Re: Kelso Crescent Multi-Level Warehouse, Moorebank (SSD-58978472)

Liverpool City Council was invited to provide comments during the exhibition of a State Significant Development Application for a Multi-Level Warehouse at 20 Kelso Crescent, Moorebank (Lot 2 DP 521146 and Lot C DP 327378).

Attachment A – Detailed Comments

COMBINED ESTATE ENTRY & TRUCK ENTRY/EXIT SIGN

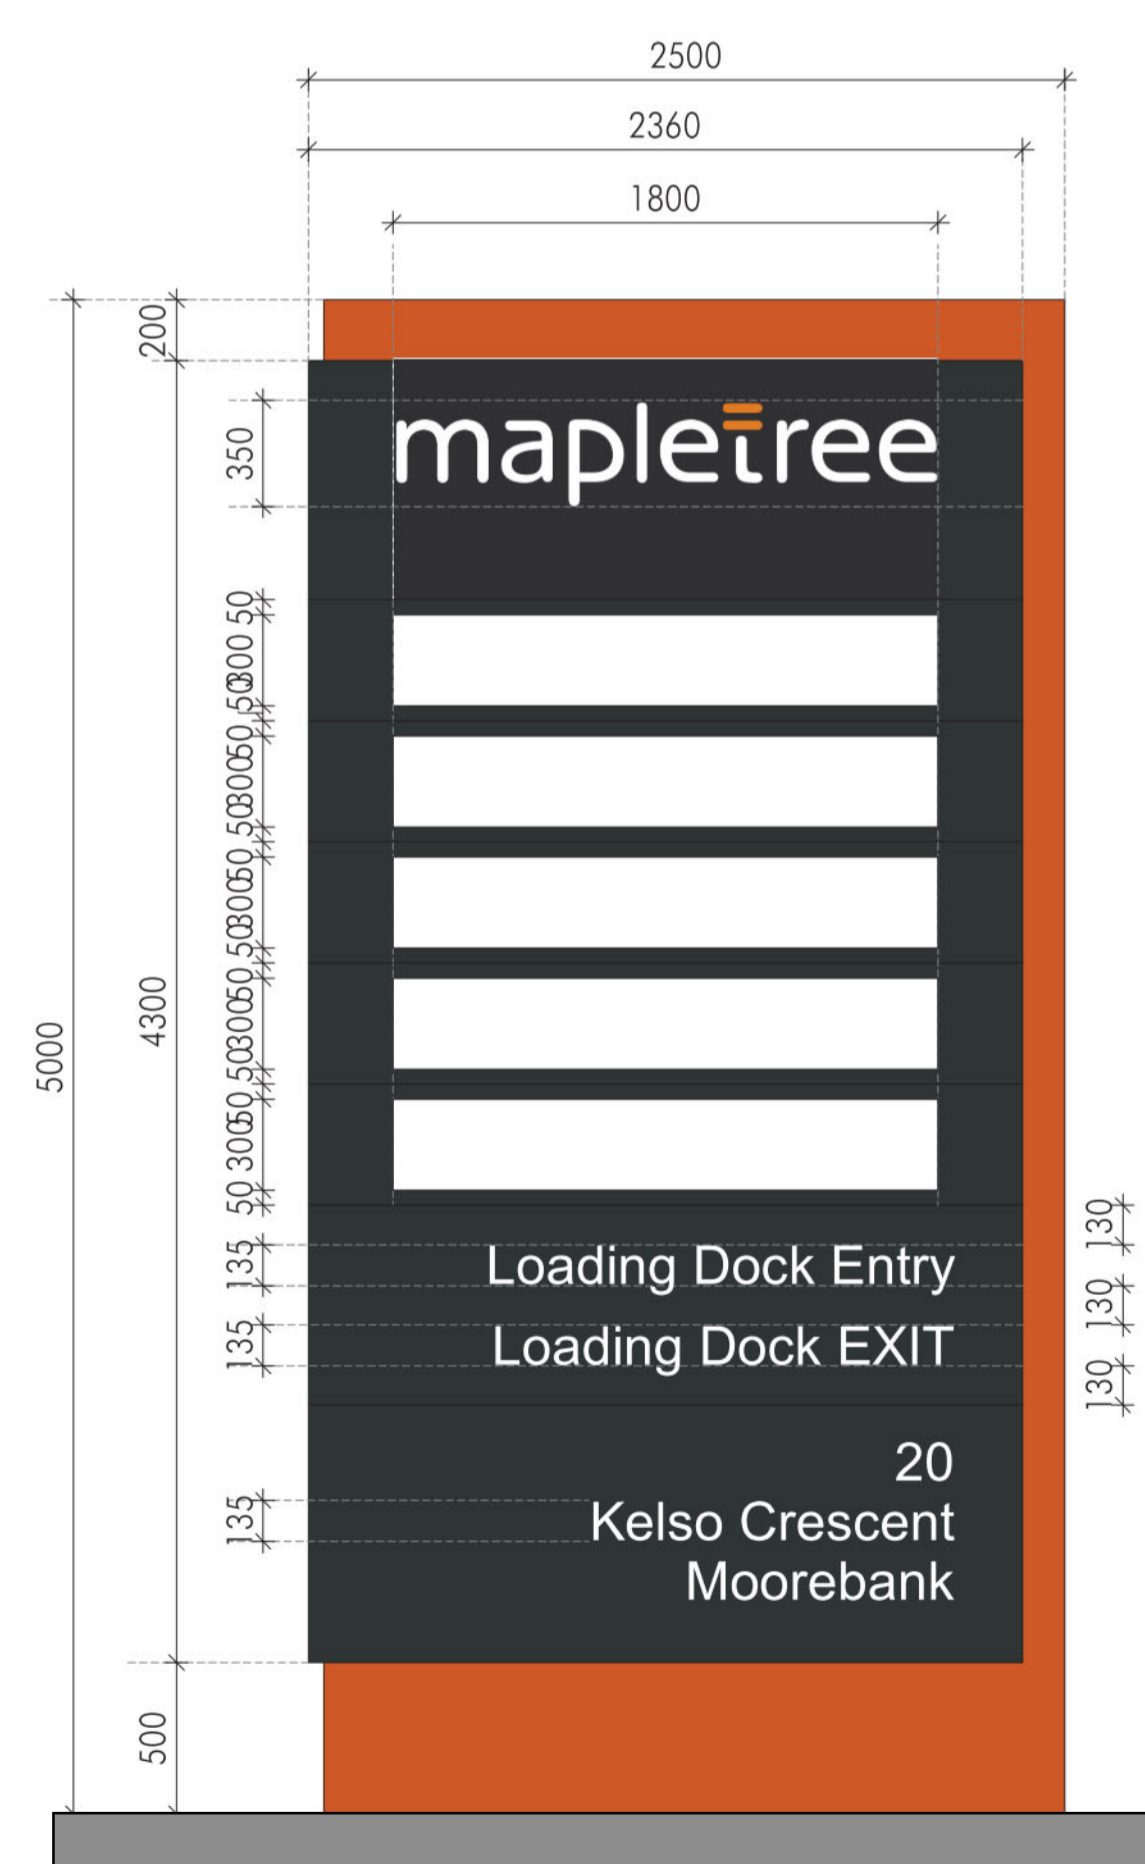
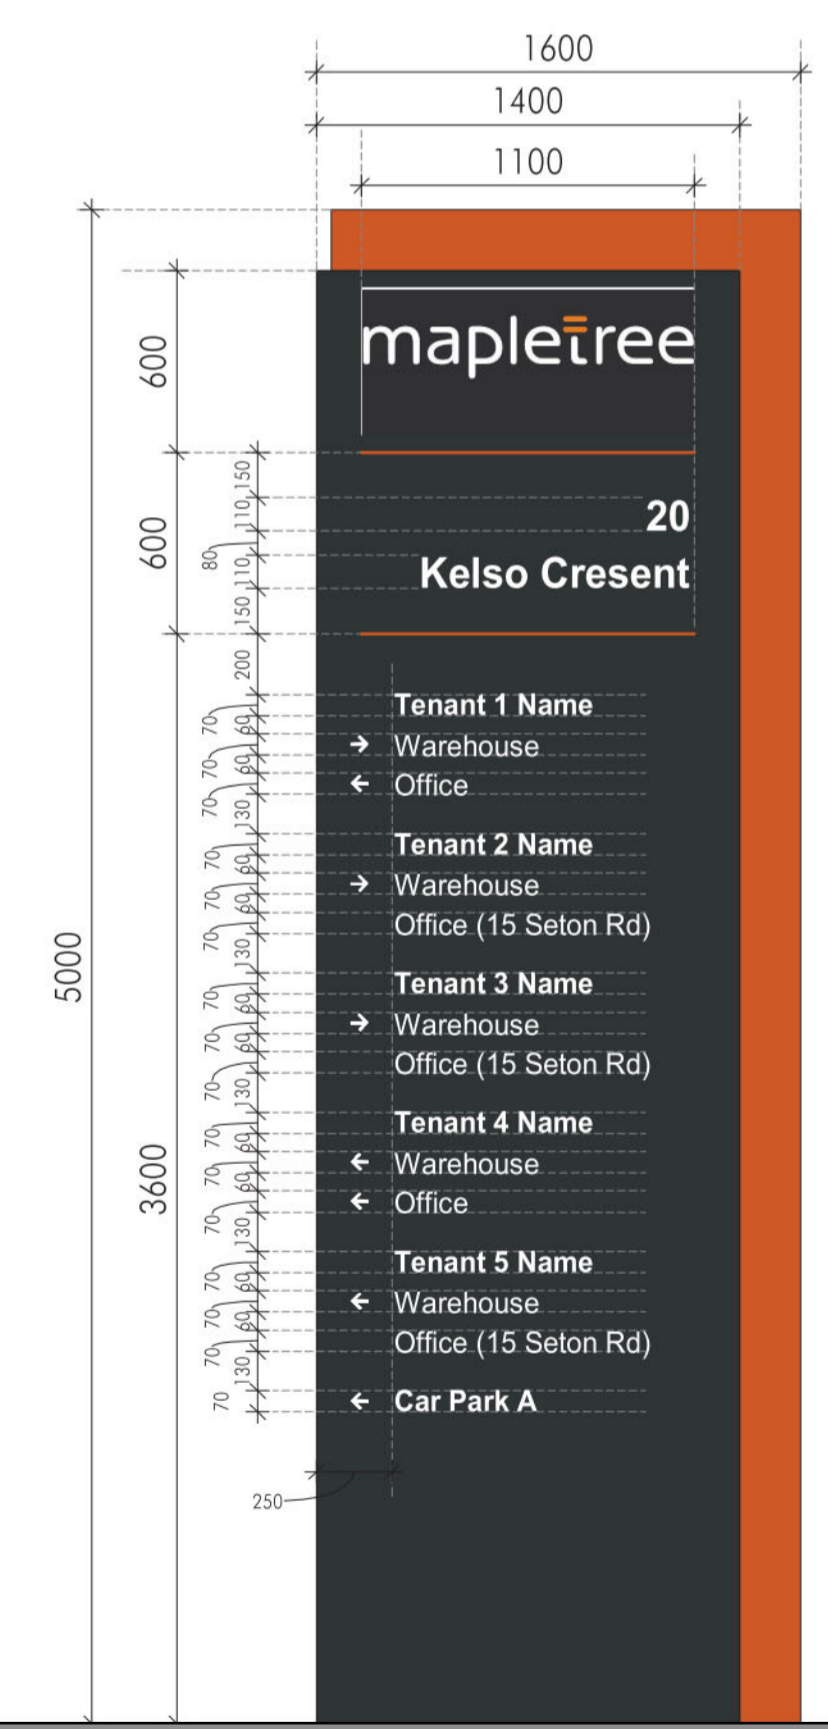
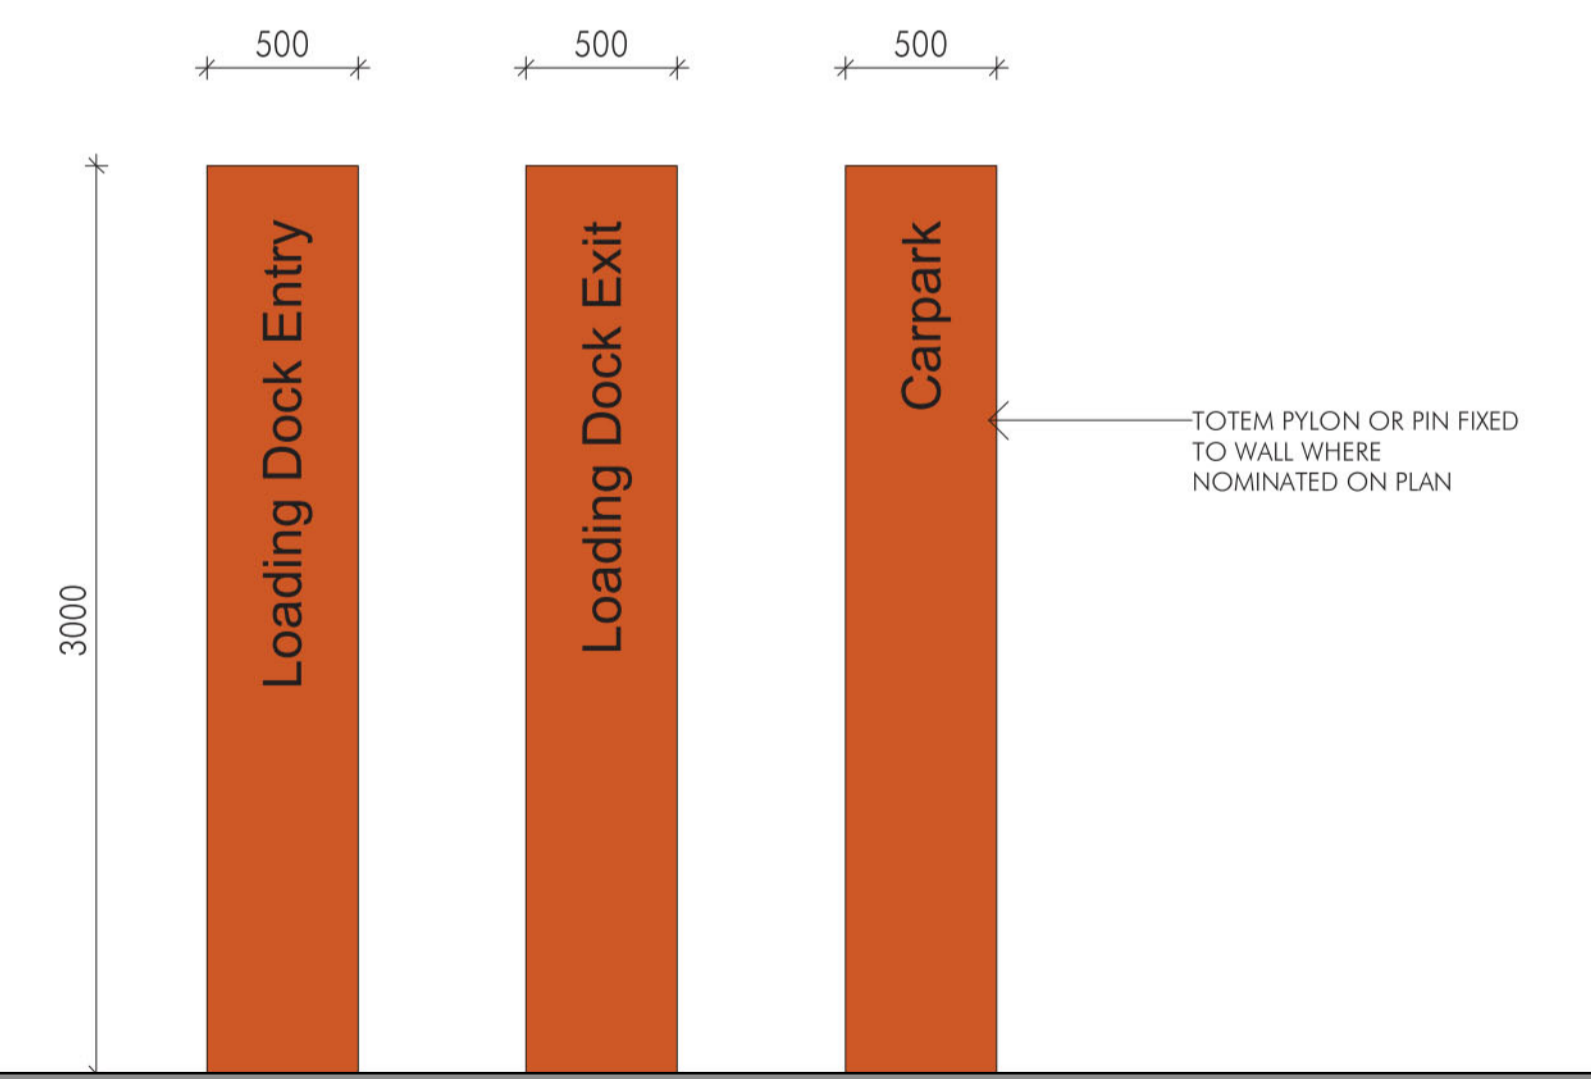
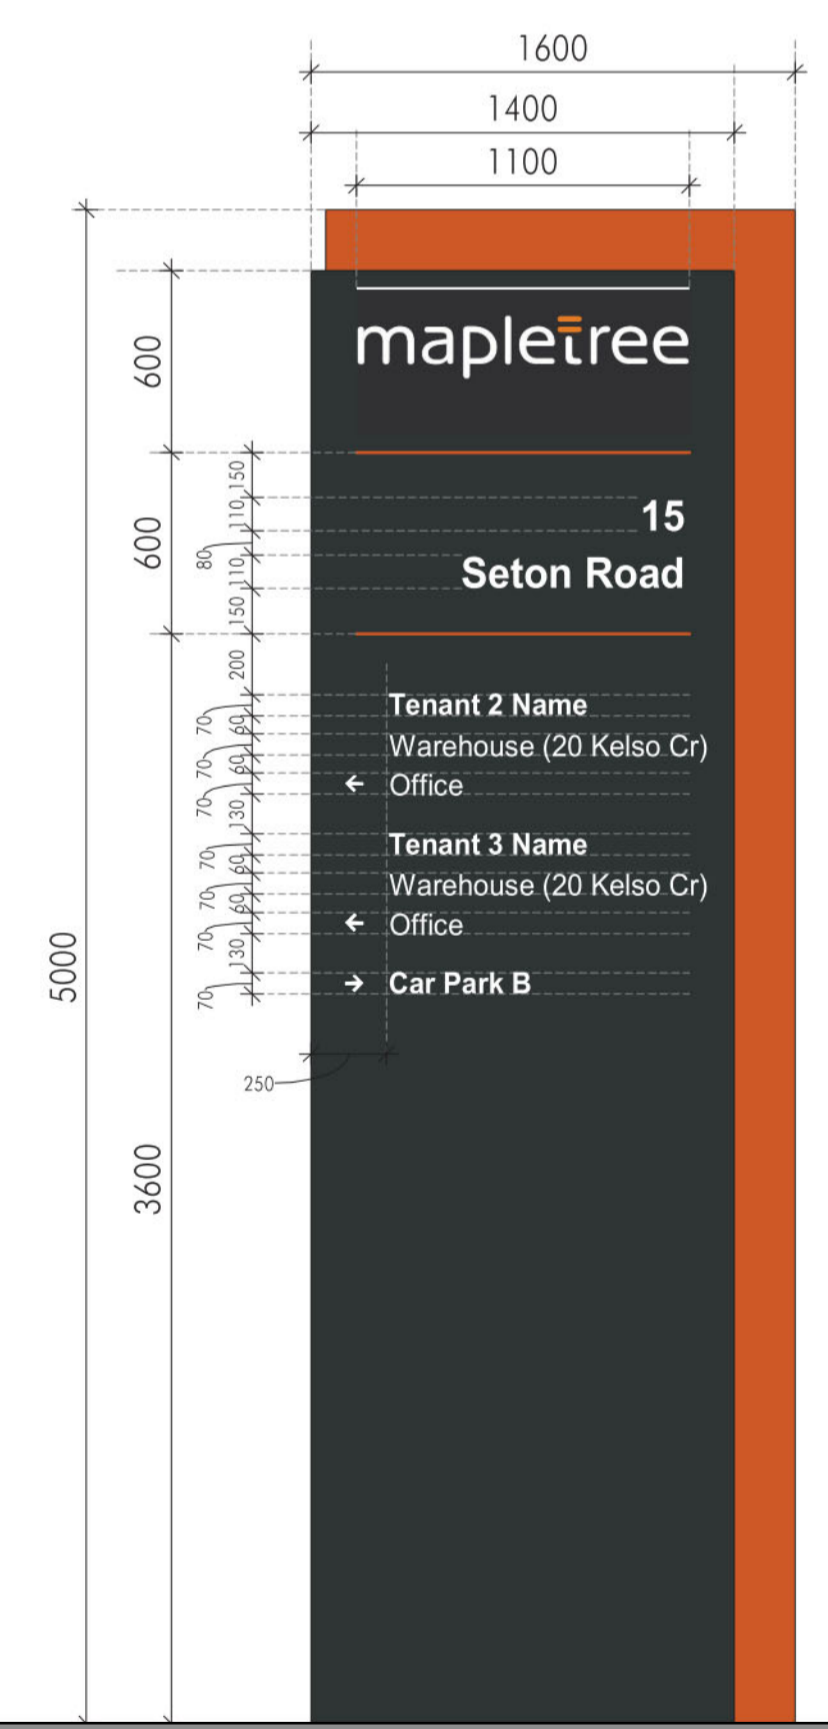
The signage proposed as part of this application seems excessive. The DCP (Part 1, Section 26 ‘Outdoor Advertising and Signage’) limits free standing signs to a maximum 5m in height. Council requests the proposal is amended to comply with Council’s DCP.
